***Lot 1 DP 702144 & Lot 100 DP 624581  
86-96 and 100 Mount Street, North Sydney***

***MP 08\_0241 MOD 2 – Modification to the approved  
Commercial and Retail Development***

Secretary's Environmental Assessment Report  
Section 75W of the *Environmental Planning and  
Assessment Act 1979*

drawing
 Retail Level Plan

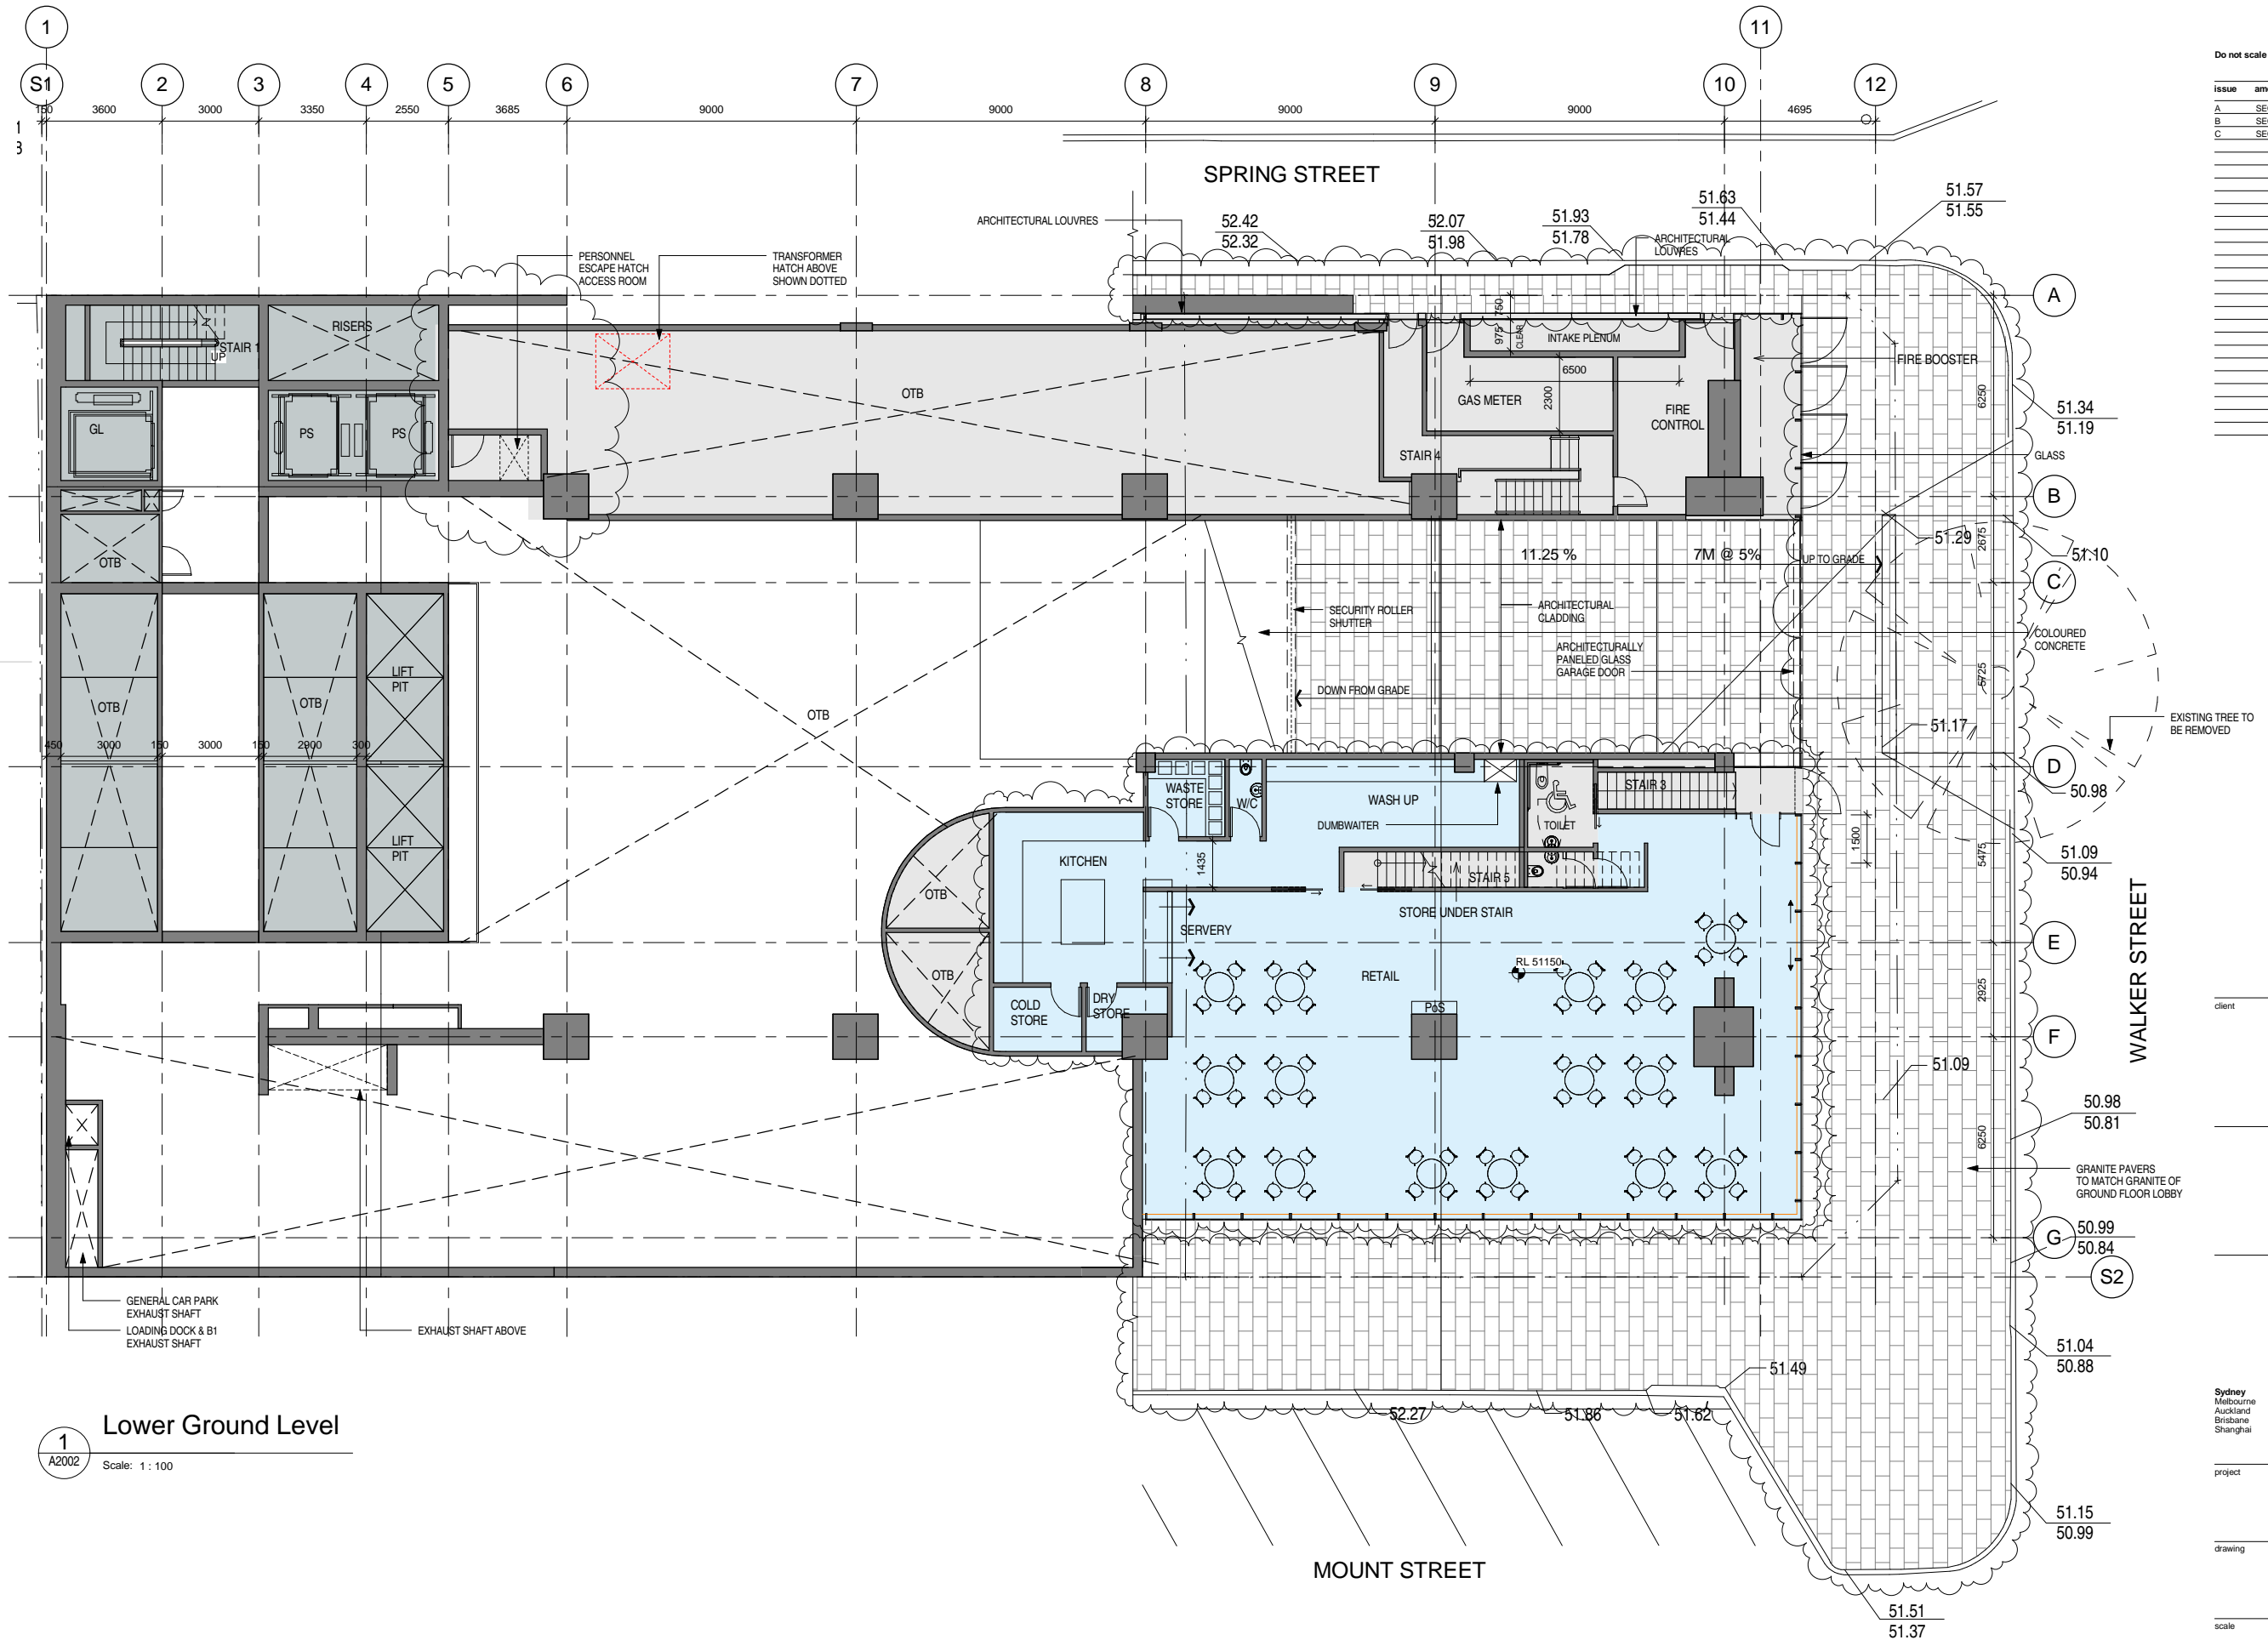
- increase in the size of the retail/café area and outdoor seating area;
- enclosure of the ground floor café and through site link with glazing for weather protection;
- granite pavers for the public domain (Walker, Spring and Mount Street pavements) to be discussed and agreed with Council;
- provision of 28 external bicycle spaces in the south western corner of the site, and 10 spaces in the north western corner of the site;
- reduction of street trees at Walker Street from three to two to make allowance for car park driveway cross over to the site; and
- other minor layout changes (**Figure 7**).

The Department concludes that the proposed changes are acceptable. The modifications to the lower ground floor and ground floor levels will improve the overall useability of the ground floor space and public domain. Further, the increase in the retail/café area will further activate the façade, public domain and through site access. The reduction in trees is appropriate given the original approval for three trees did not consider the requirements for a driveway crossover at Walker Street, approved as part of MOD 1.

drawing
 Plant Level Plan

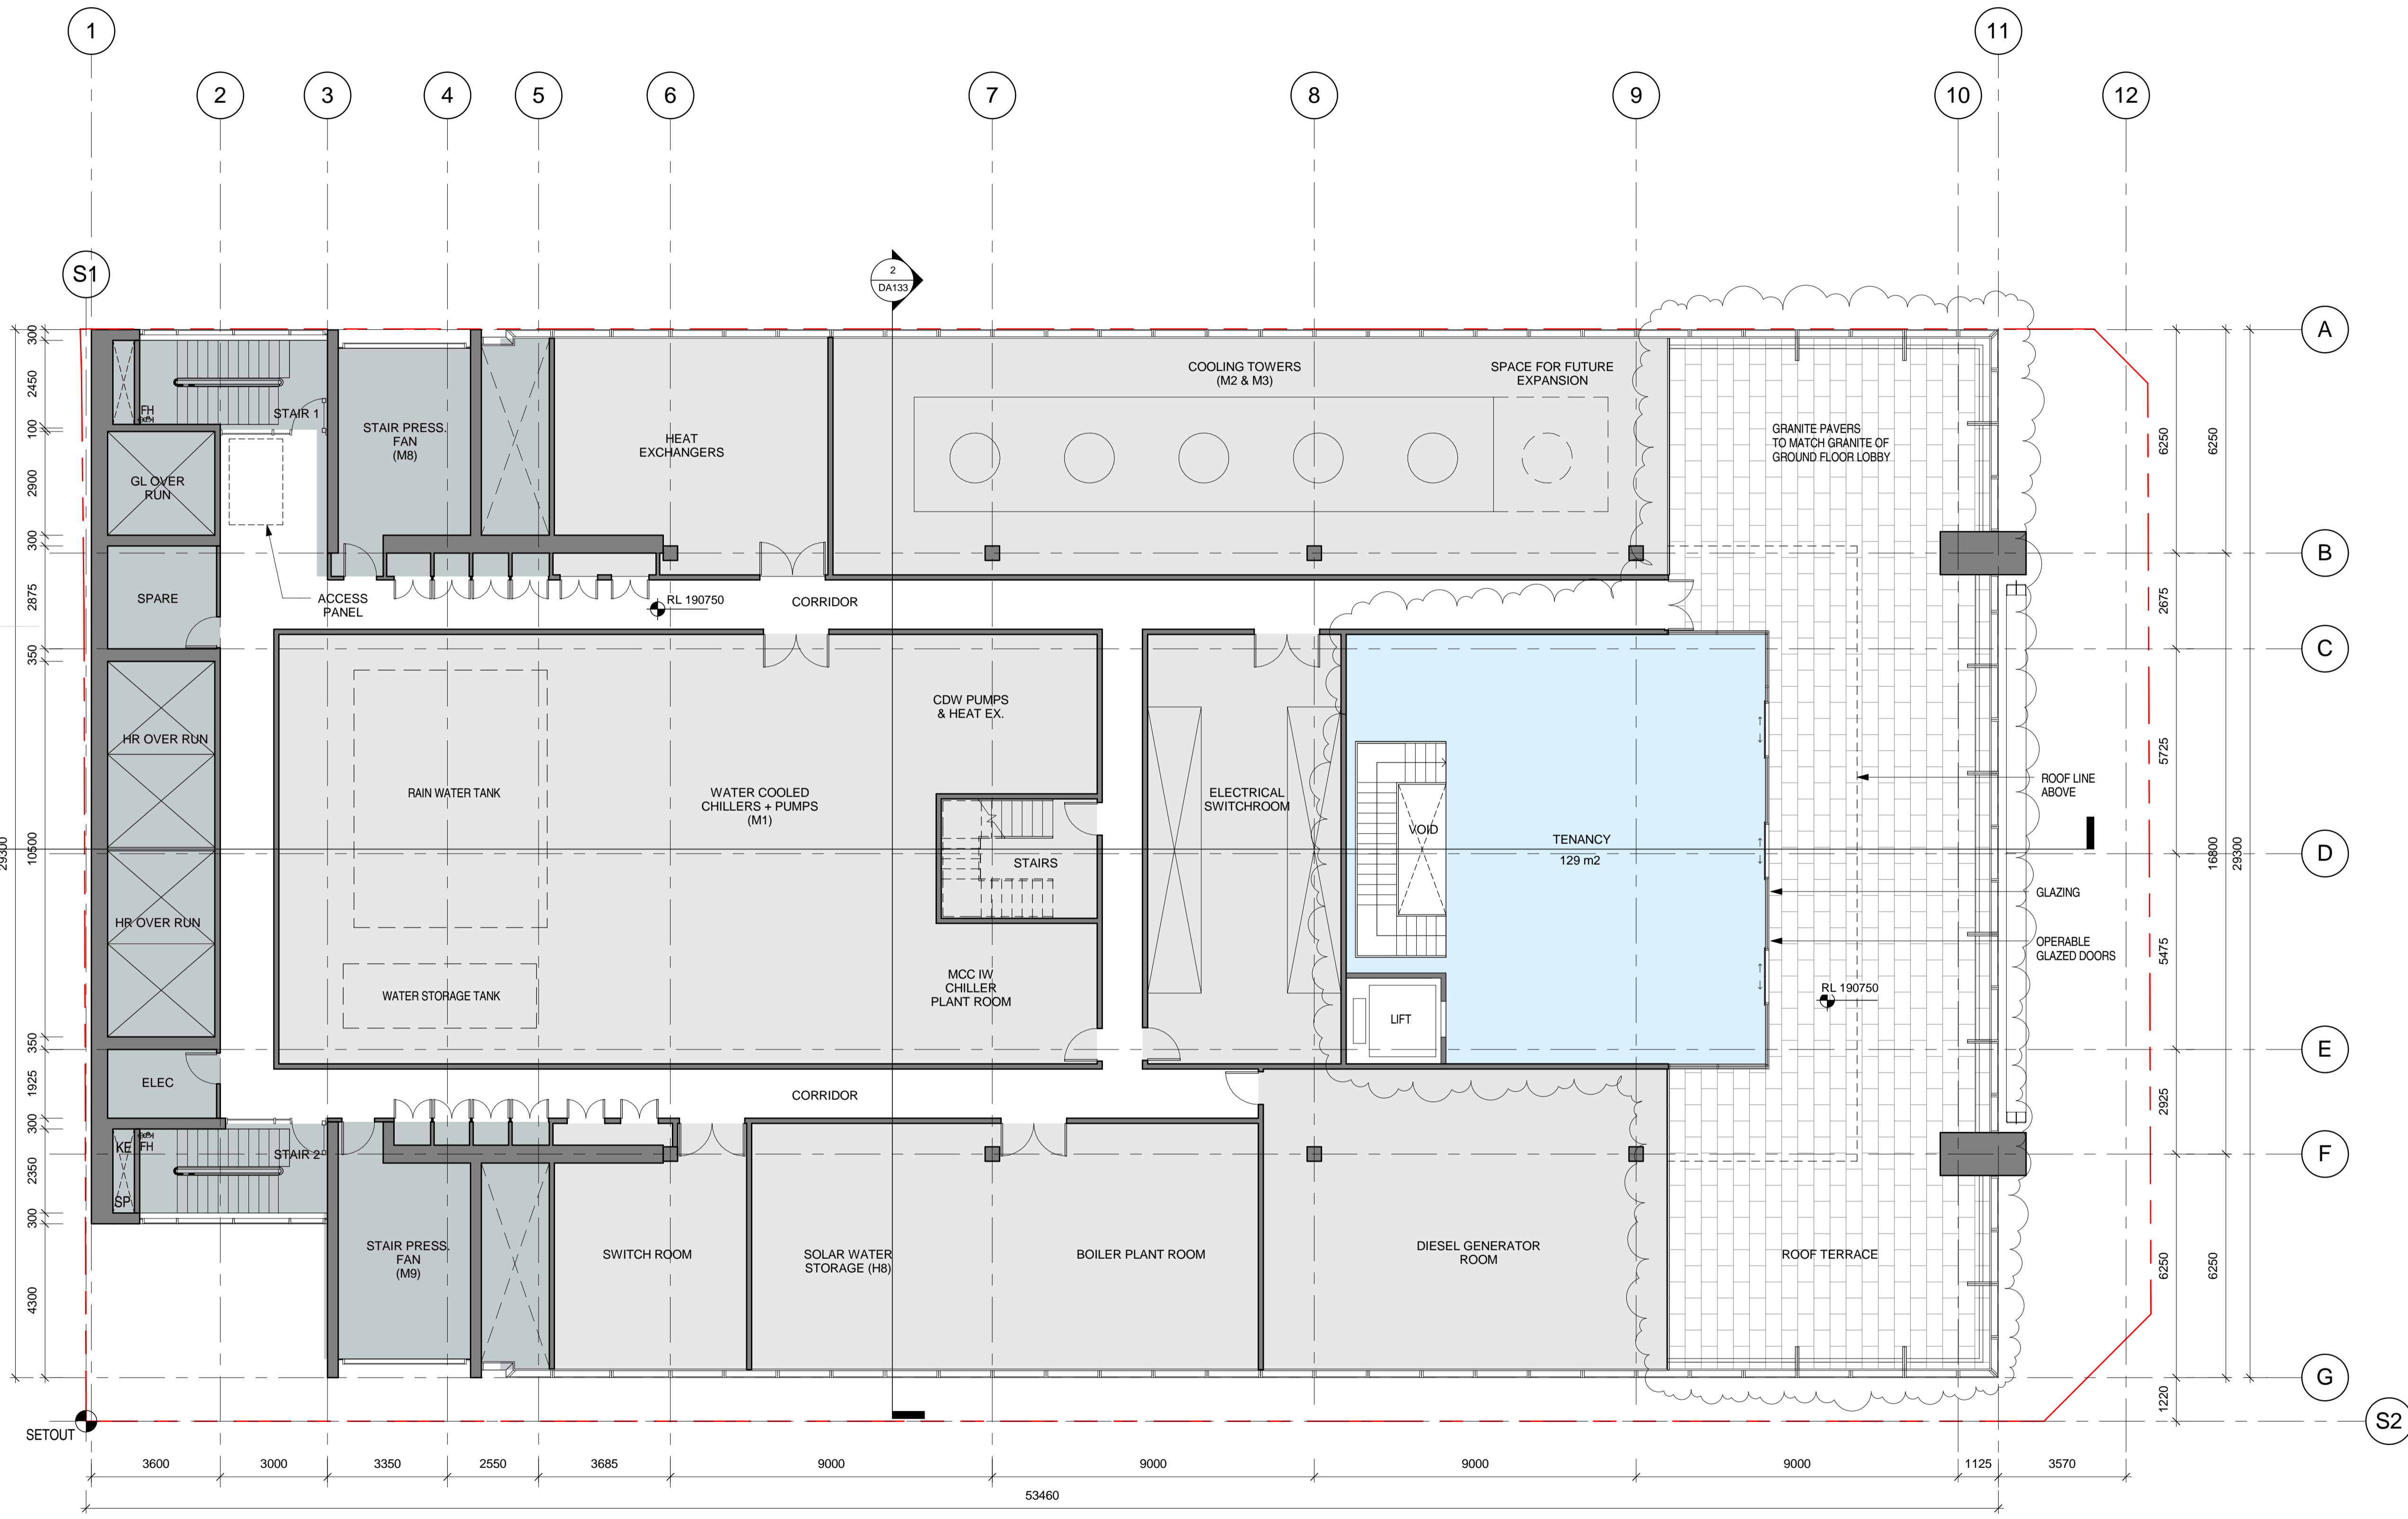
- additional commercial office space at the plant level with access to the accompanying roof terrace space at the plant level.

The Department notes the raised roof level from RL 194.7m AHD to 196.7m AHD enables the provision of an additional plant mezzanine level comprised of some plant and mainly void areas. Whilst the roof level is raised the Department notes the maximum building height of the building is reduced by 1.7 metres (from RL 199.7m AHD to RL 198m AHD). The Department is satisfied the minor increase in the height of the roof level and overall mass of the building would not be discernable from the street level. Further the overshadowing impact would be consistent with that approved given the approved development comprised parapet brace blades which provide a similar overshadowing impact as the proposal.

The Department concludes that the proposed external modifications are minor and will provide a refined appearance to the building particularly at the upper level, screening plant from view. The removal of louvres to provide windows for bathrooms, and enclosure of the ground floor lobby with glazing will enhance the amenity of future building occupants.
